Our Ref: WA/53/20/NMA

**Section 96A of the Town & Country Planning Act 1990 (as amended)
Town and Country Planning (Development Management Procedure) (England) Order 2015 (as amended) - Article 10**

Non material amendment following grant of WA/36/20/HH for the increased width of proposed kitchen and reduced width of proposed study.

Murroes Dairy Lane Walberton BN18 0PT

project: 20/C05
drawing no: 3b
date: March 2020

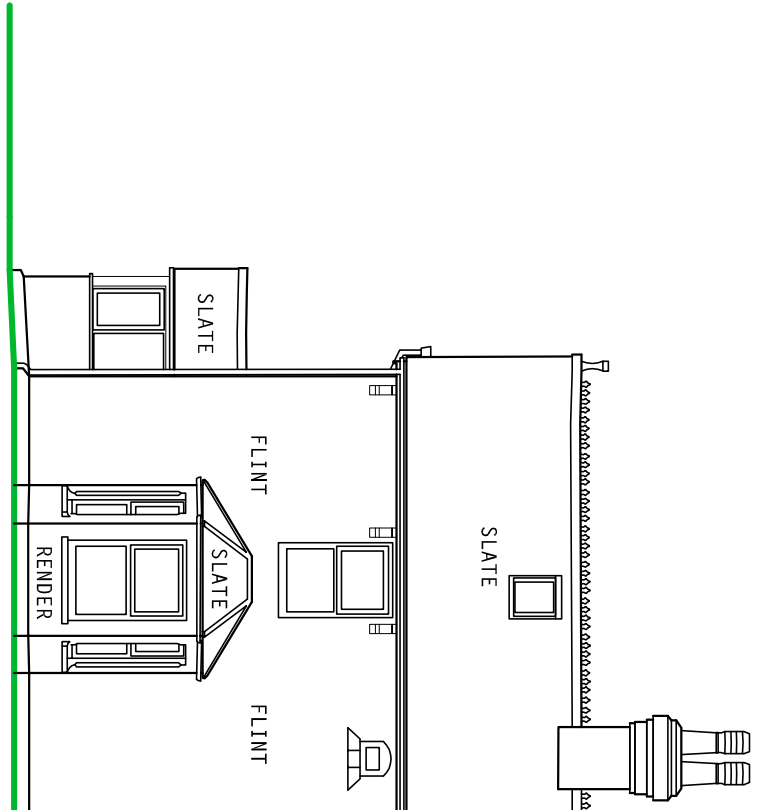
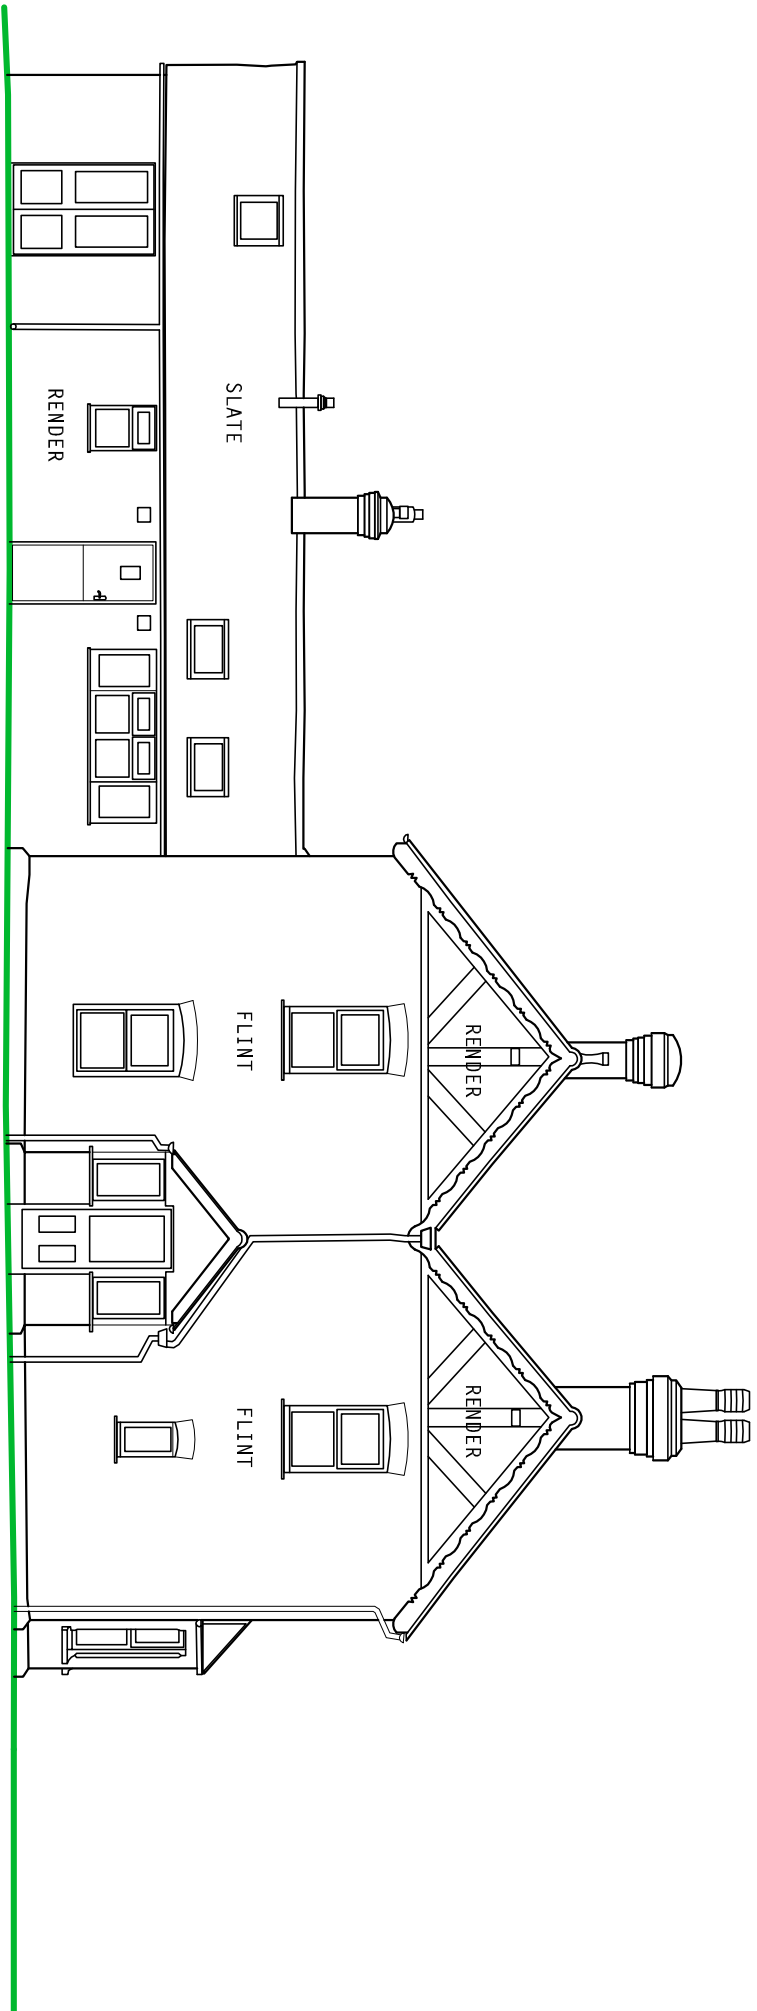
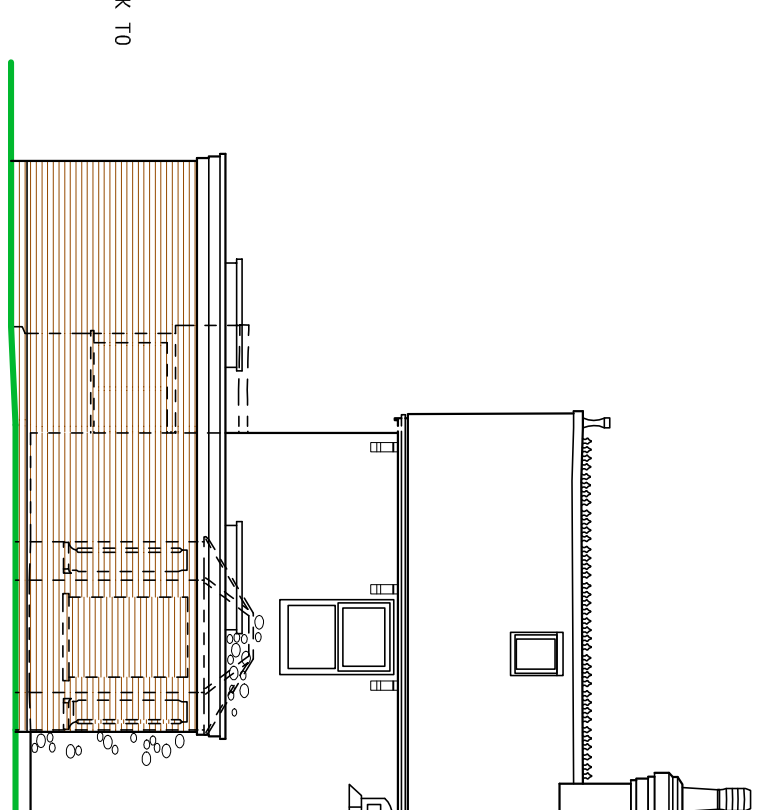
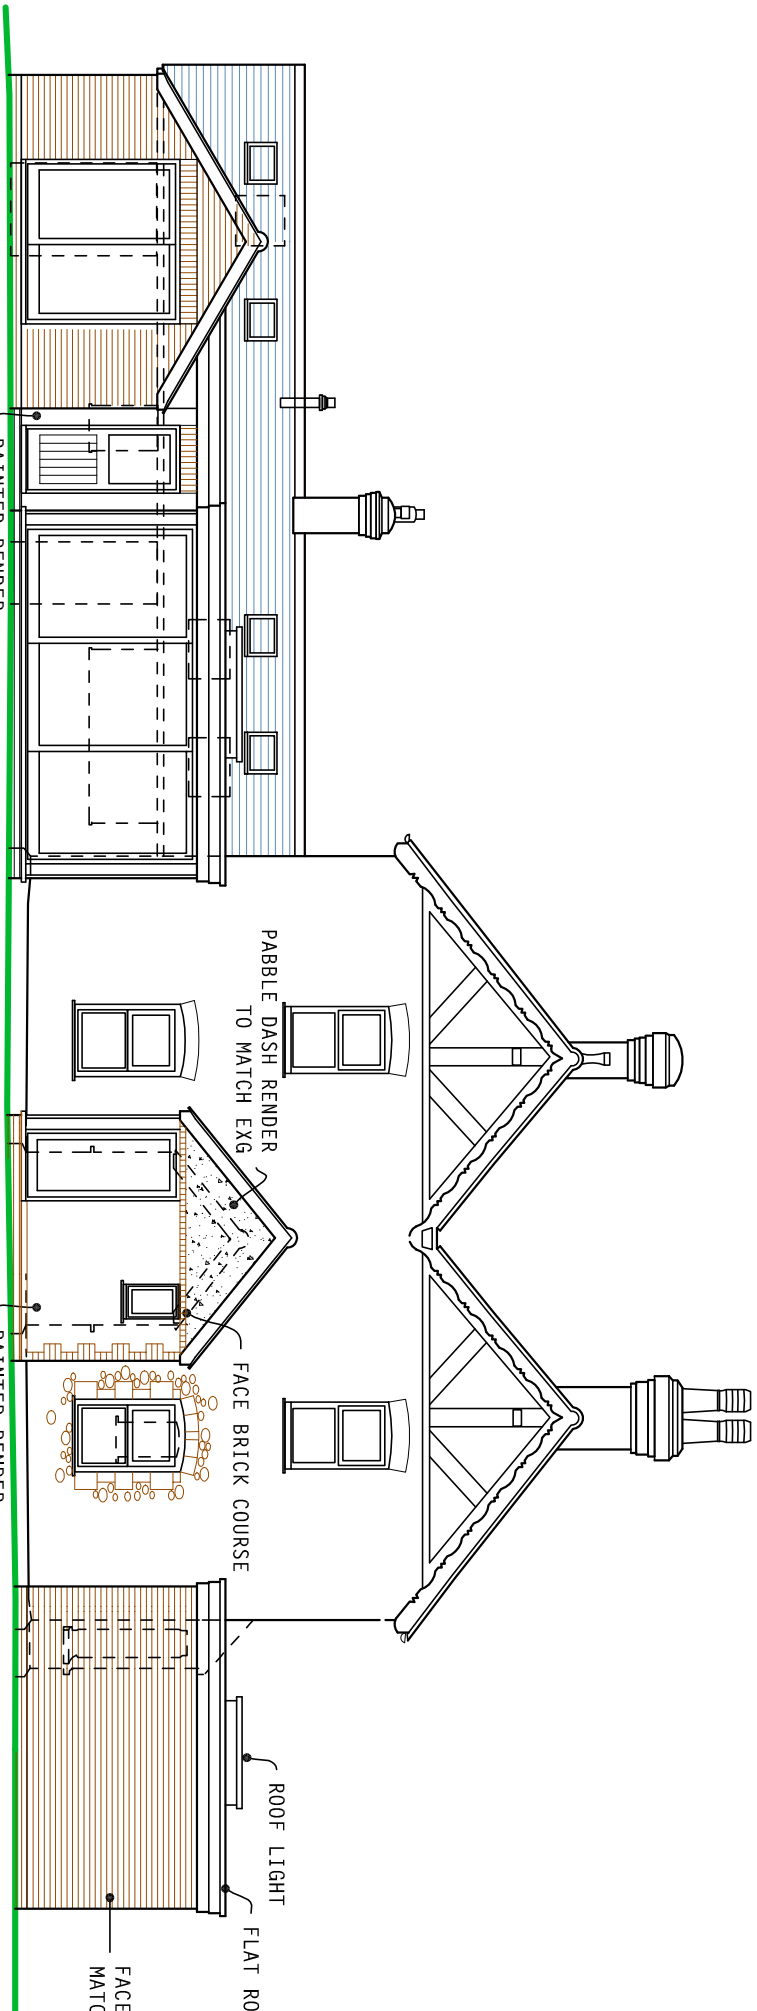
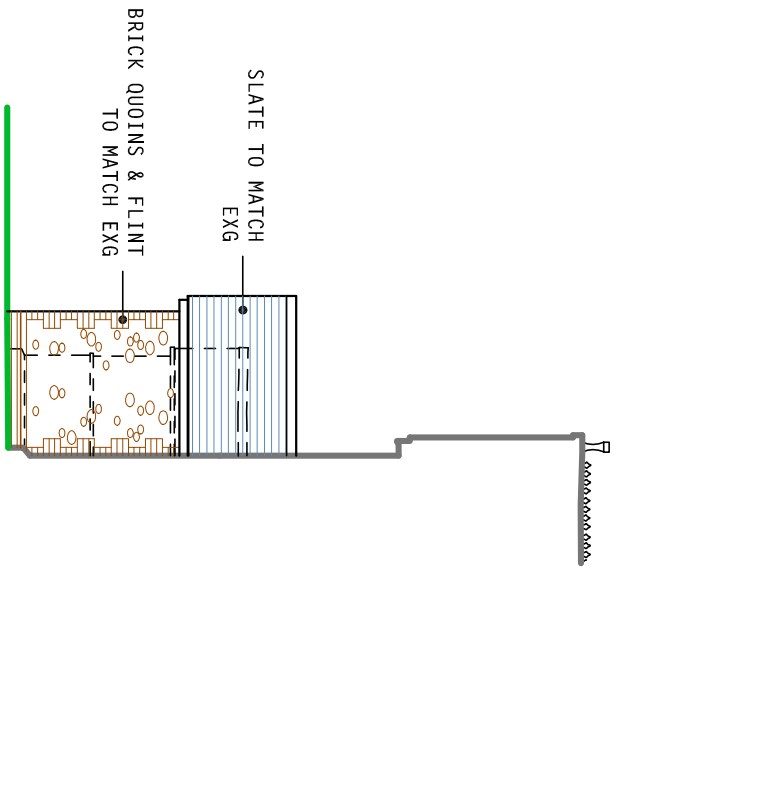
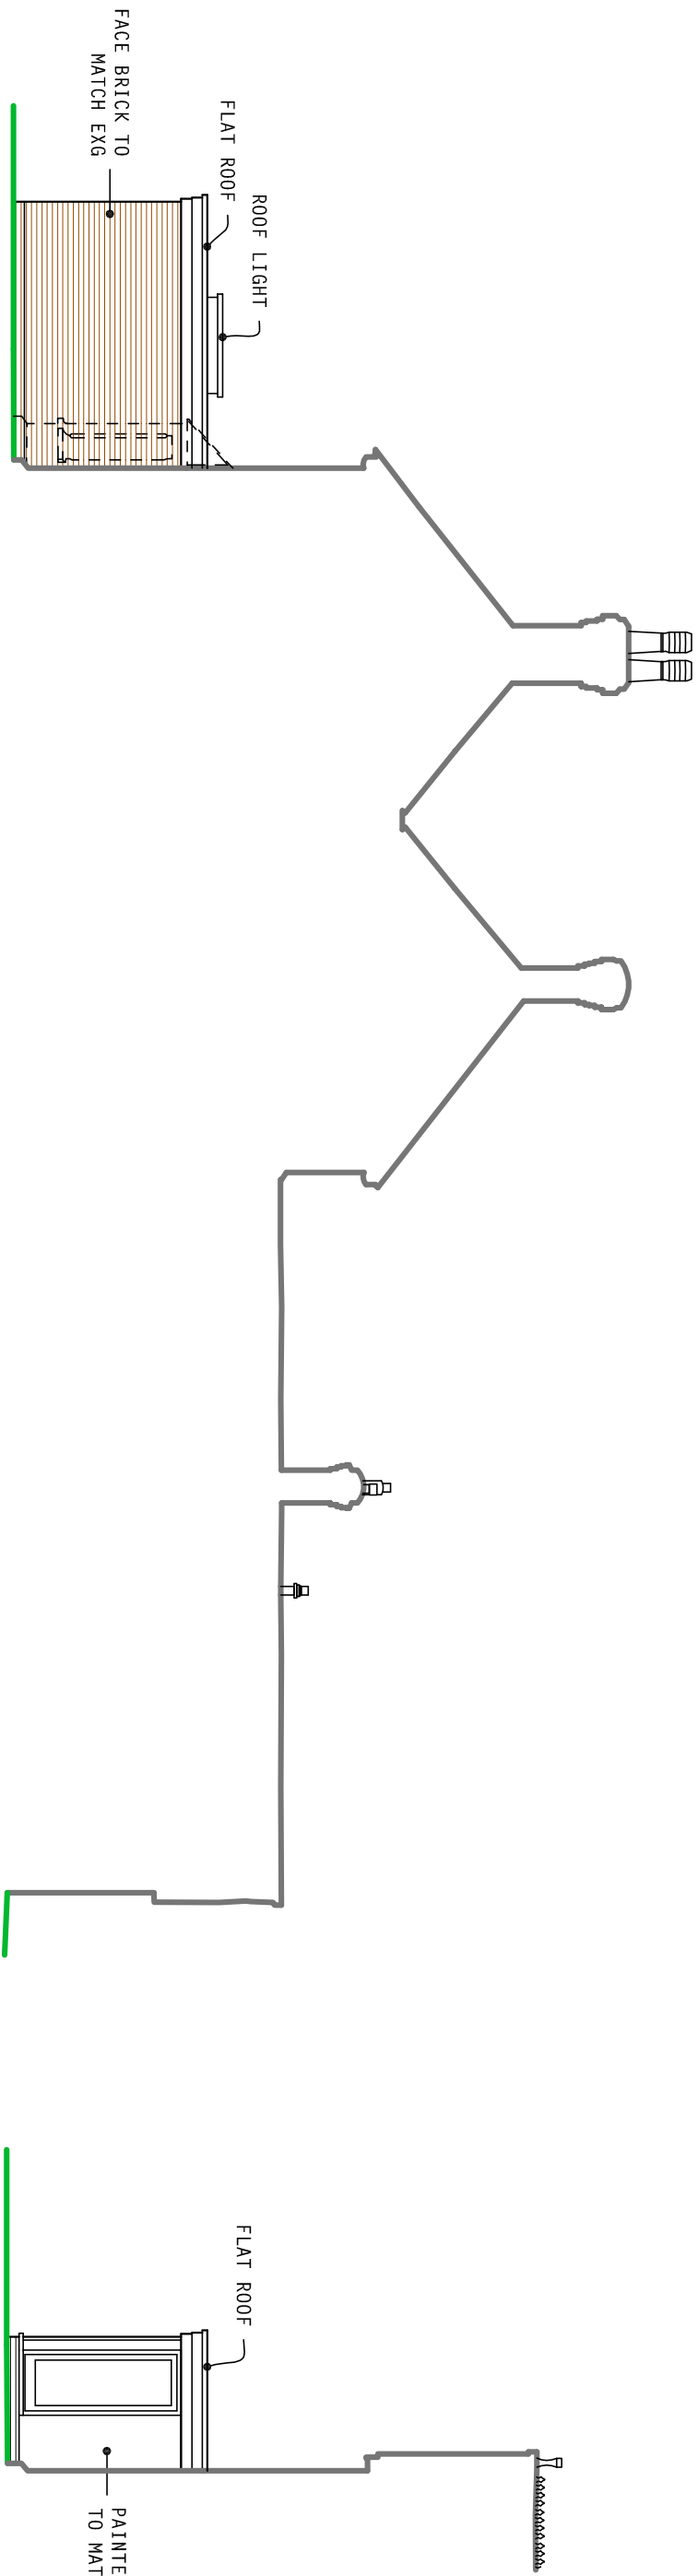
The approved plans 'Plans - 20/C05 - 3b - March 2020' and 'Plans - 20/C05 - 2c - March 2020' are hereby replaced by 'Plans - 20/C05 - 3c - March 2020' and 'Plans - 20/C05 - 2d - March 2020'.
